**TO:** Elizabeth Nijkamp, Engineer Review Manager, El Paso County

**DATE:** January 5, 2023

**SUBJECT:** **On-Call Contract #17-067H-1; PO # 8115428**  
**Traffic Impact Study Reviews**  
**Task Order #11: Sterling Ranch East – Phase I Preliminary Plan TIS (SP224)**  
**First Review**

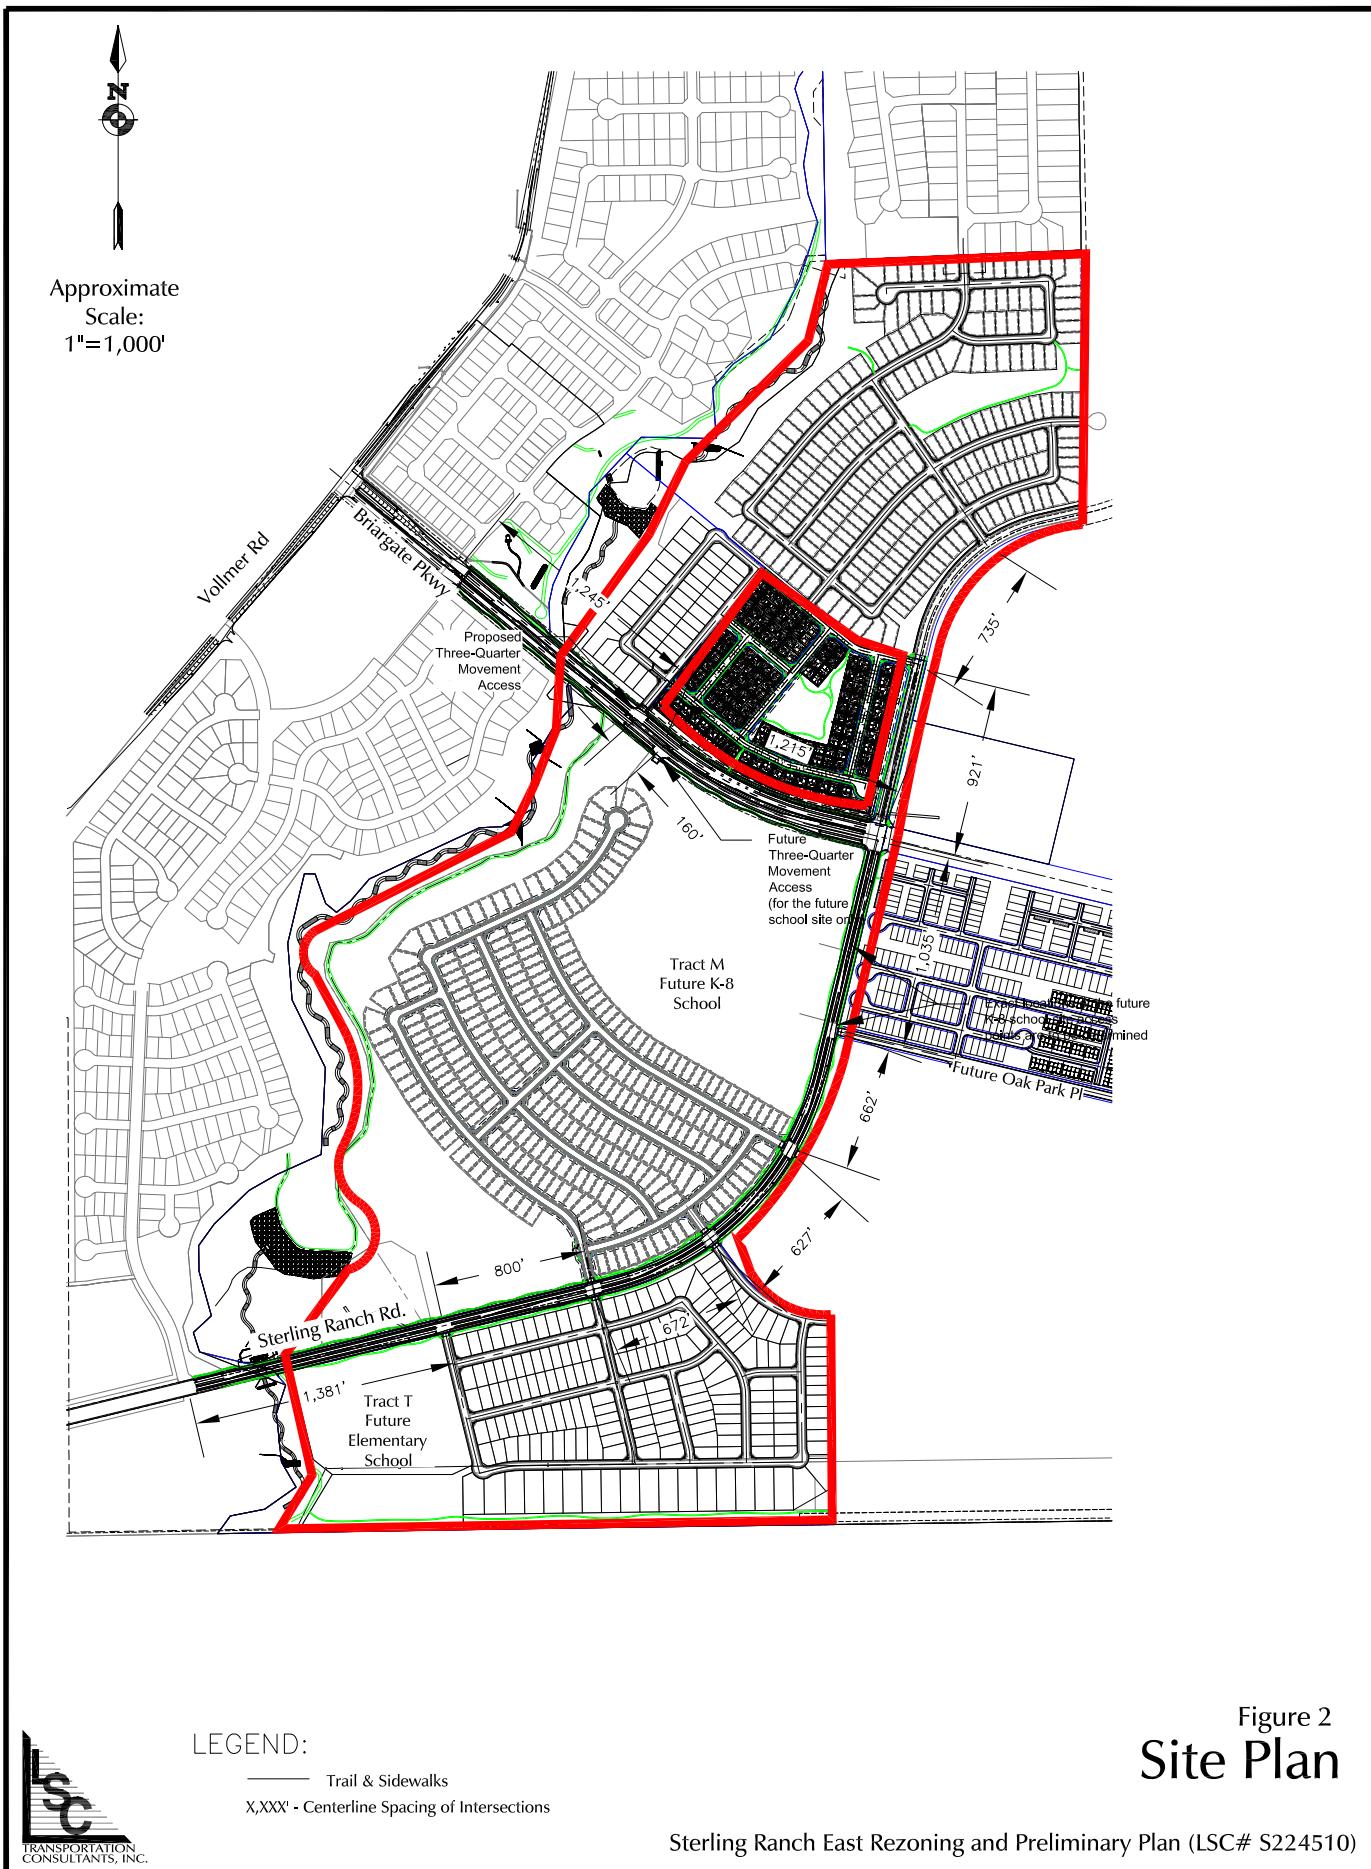
- b. The operational analysis (page 11) describes an exit-only access for Tract M along Sterling Ranch Road at Oak Park Place (#8). This access is not described elsewhere in the TIS, including the access text on page 3, the roadway connections on Figure 3, or the sight distance analysis on Figure 4a. The entry-only access to Tract M along Sterling Ranch Road

(#307) is also not described in the TIS, including the access text on page 3, the Sterling Ranch Road site access points on page 12, the roadway connections on Figure 3, or the sight distance analysis on Figure 4a. Both accesses are within 1,250 feet of the Briargate Parkway / Sterling Ranch Road signal and may conflict with turn lanes or queues approaching the signal. The Tract M access along Briargate Parkway was also noted as a concern in our Master TIS review.
